March 22, 2019

**SUBJECT: Settlers Ranch Filing No. 2C  
Response to County Review Comments  
SF-18-18**

PCD File No. SF-18-018

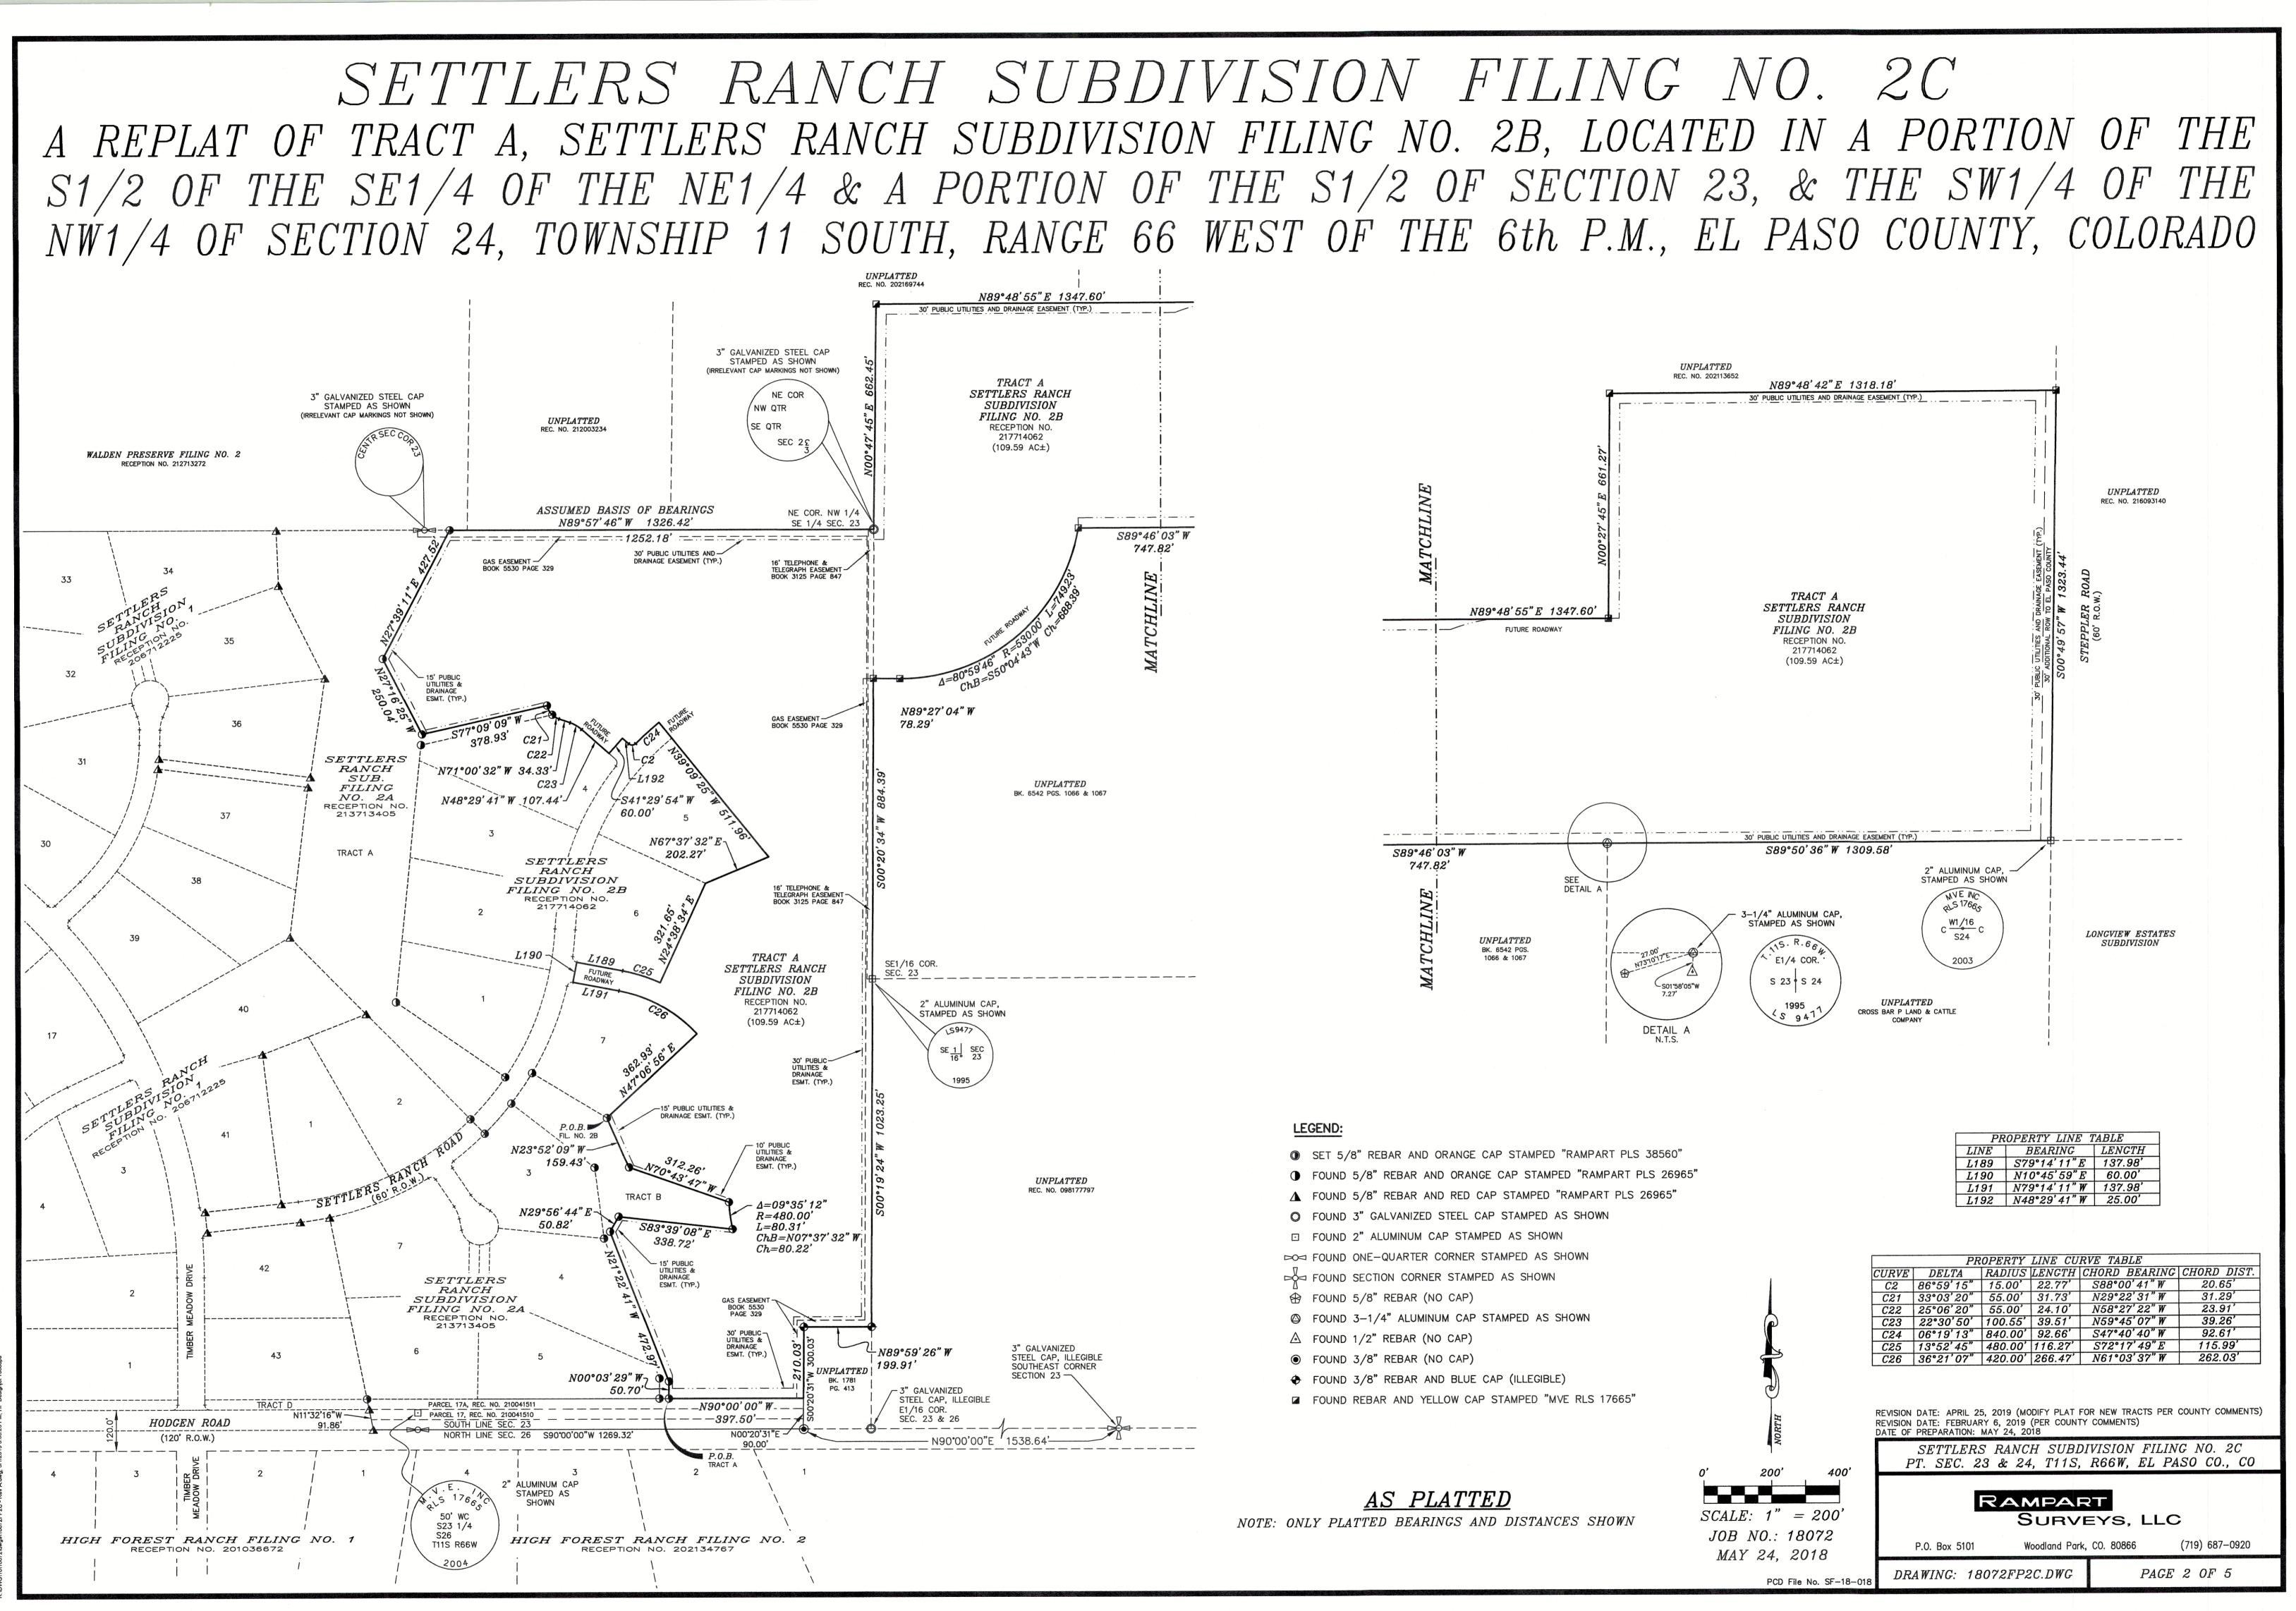
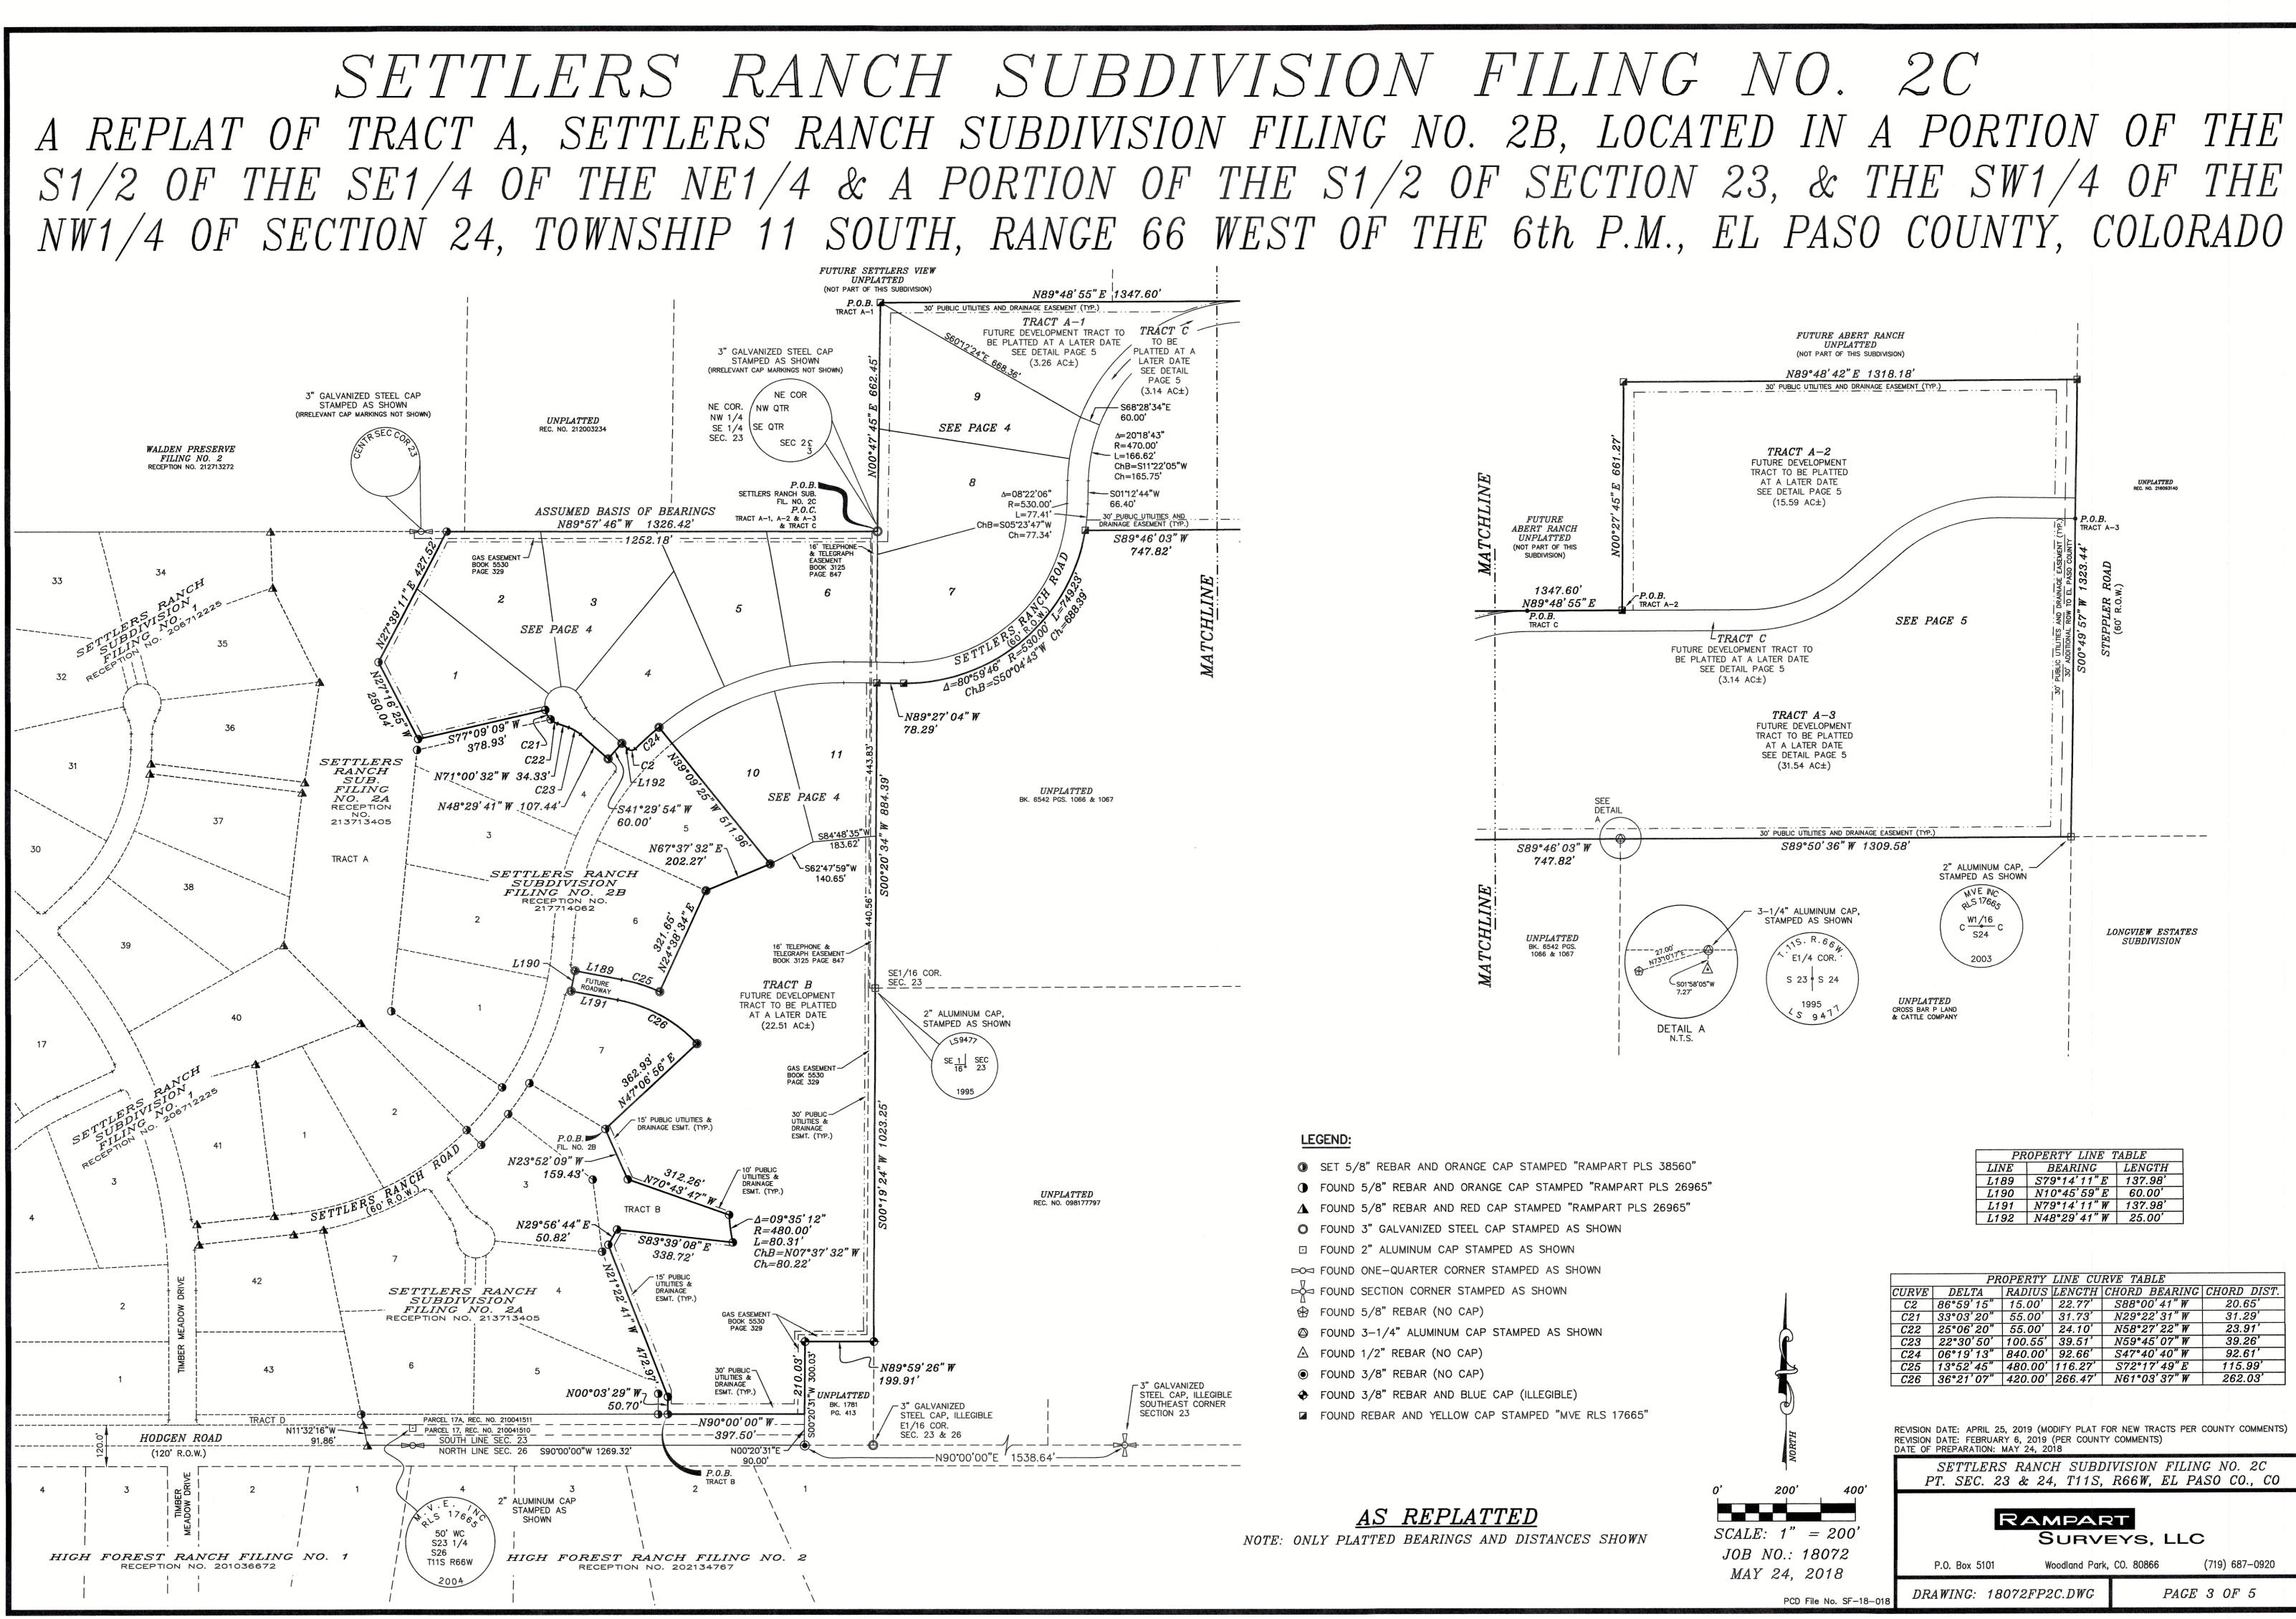
MVEA acknowledges the easements shown in the plat of ten (10) foot side, fifteen (15) rear and twenty (20) foot front lot line utility easement along with a thirty (30) foot exterior easement on plat. MVEA request utility easements be included with the Public Improvement Easements along the front lot and tract line to aid in the design and the platting of existing MVEA facilities with easement on the plat. If open space, drainage and landscape tracts are designed in this filing MVEA requests these areas be listed to include utilities. Additional easements may be required once a review of civil drawings with grading and erosion plan is provided to MVEA in order to serve this subdivision. **(Utility easements are included with the Public Improvement Easements as stated in easement note - overlaps 5' public improvements easement for a total of 20 feet)**
